**KIRKLEES METROPOLITAN COUNCIL  
INVESTMENT & REGENERATION SERVICE**

**DELEGATED DECISION TO DETERMINE PLANNING APPLICATIONS**

Reference No:	<b>2025/62/93136/W</b>
Site Address:	opp, 36, New Street, Huddersfield, HD1 2BU
Description:	Installation of 1 black digital communications kiosk with defibrillator (within a Conservation Area)
Recommending Officer:	Joanna Rednall

## **Officer Report 2025/93136 opp, 36, New Street, Huddersfield, HD1 2BU**

NWP-KIOSK/001

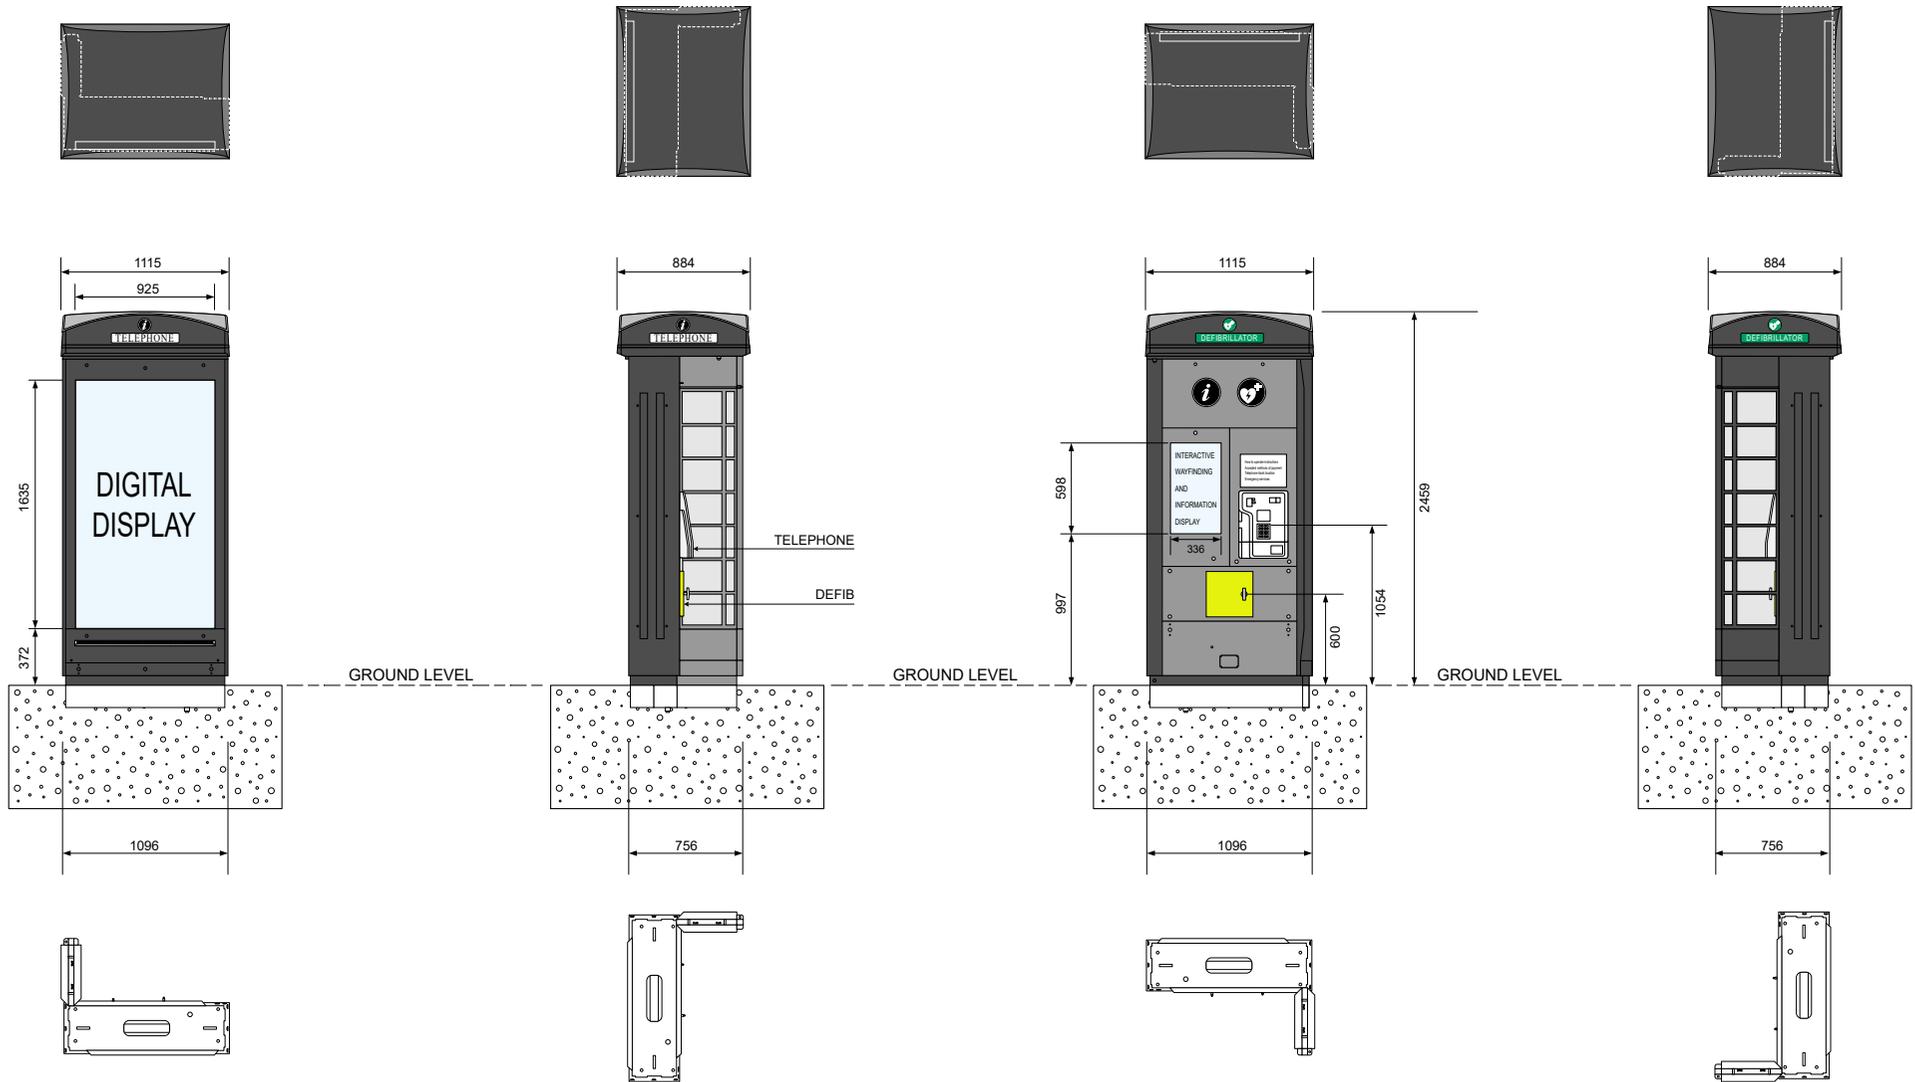
A telephone box is located approximately 30 m south of the application site; however, the proposal does not include its removal. As a result, the introduction of the communications kiosk would add to, rather than reduce, existing street clutter. Although the kiosk would have a smaller footprint than the existing phone box, it would stand at a height of approximately 2.4 m and occupy a prominent position within the pedestrianised footway. This

prominence would be further emphasised by the 1.6 m high internally illuminated digital screens on the sides of the structure, resulting in a visually intrusive feature that is out of keeping with the historic character of the surrounding streetscape.

For these reasons, officers consider that the proposal would result in less-than-substantial harm to the setting of the Conservation Area and would detract from visual amenity by introducing additional clutter within a pedestrianised environment.

The proposed digital communications kiosk and defibrillator, due to its scale, prominent location, and illuminated displays, would constitute a visually incongruous and intrusive feature. It would harm the significance of the Huddersfield Town Centre Conservation Area, which includes several nearby listed buildings. The limited public benefits associated with the development do not outweigh the less-than-substantial harm to the heritage assets. Furthermore, the proposal would introduce additional illuminated street furniture, contributing to visual clutter and detracting from the character and appearance of the wider Town Centre. The proposal is therefore contrary to Policies LP17(a), LP24(a), and LP35 of the Kirklees Local Plan, Chapters 12 and 16 of the NPPF and Section 72 of the Planning (Listed Buildings and Conservation Areas) Act 1990.
